From: Matthew Symons
Sent: 07 November 2019 16:24
To: 'Caroline Ford'
Subject: FW: Oxfordshire County Council's response to 19/00963/OUT-2 Last House Adjoining And North Of Berry Hill Road, Adderbury

For a scheme of 40 dwellings comprising of 26 market homes and 14 affordable homes, we're considering the following mix:

1.5M FOOTWAY 0.5M VERGE/PED REFUGE WITH POTENTIAL BUS STOP LOCATIONS @ 1:500 SCALE

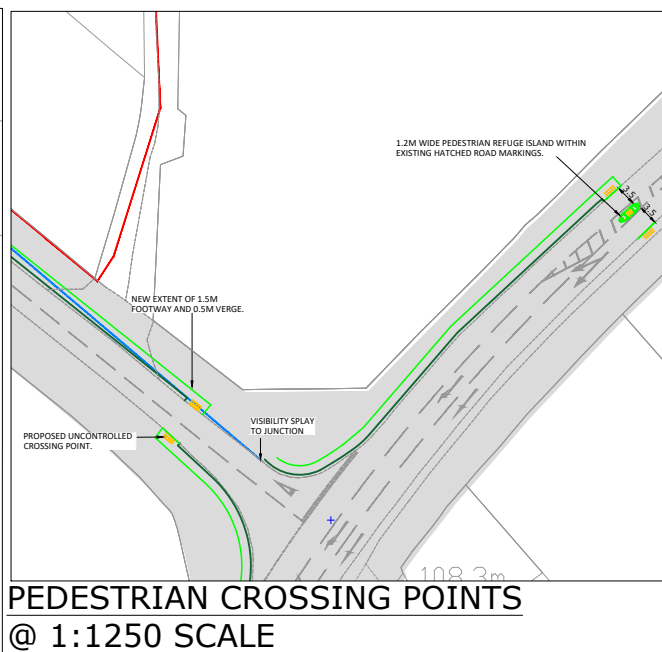
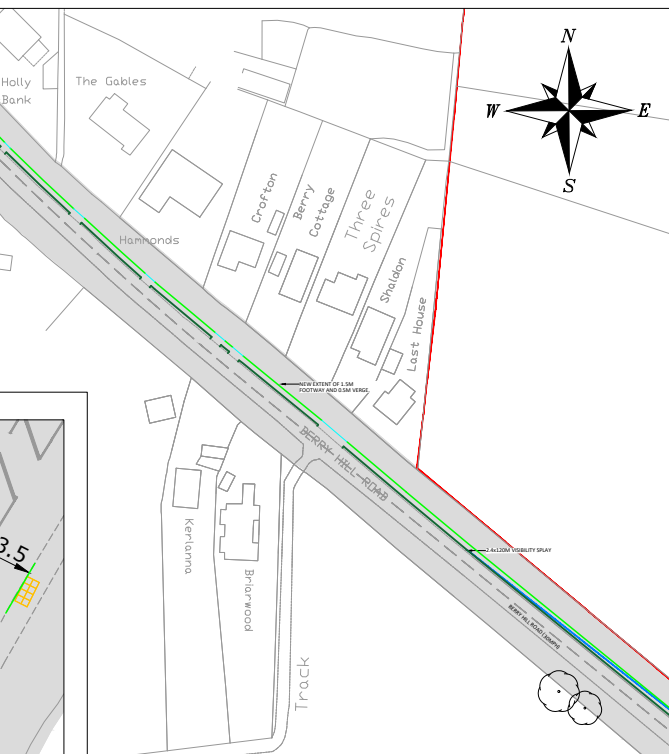
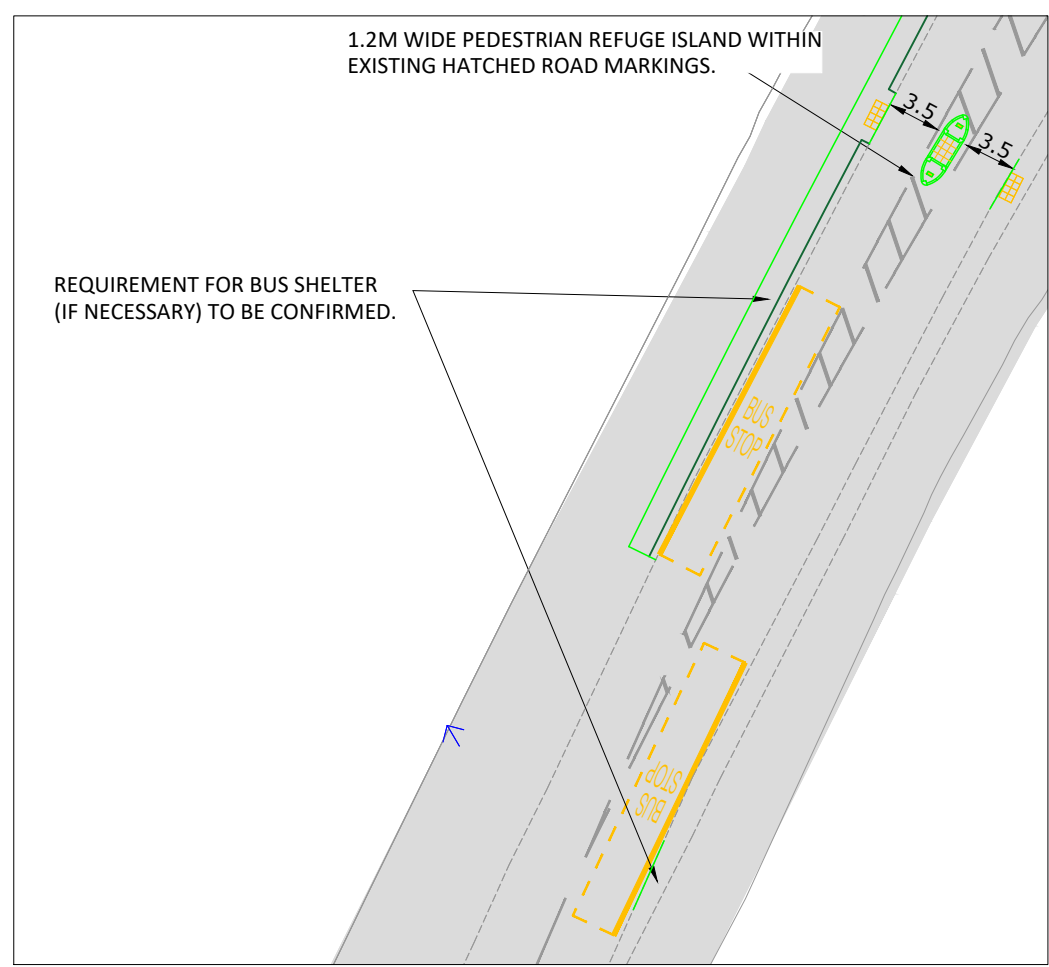
I note that they welcome the provision of the footway along Berry Hill Road. The PC suggests it should be fairly narrow and in keeping with the area. Are you happy with the footway as proposed?

The PC also refers to a possible traffic calming scheme along Berry Hill Road. Do you have access to any further information on this?

There is no mention of the proposed bus stops on the A4260 and I wondered if you could ask them to comment on these? I assume they will be seen as a benefit too given the 106 request for money to pump prime services along the A4260.

In terms of the footway, I think this will be a matter that I will query with OCC – I understand where the Parish are coming from but if it is required to be adoptable then it may need to be provided to a certain standard and width. The other issue is one of accessibility for pushchairs and individuals with disabilities.

In terms of traffic calming along Berry Hill Road – I don't have any further information but the County Council might – again I will query that.
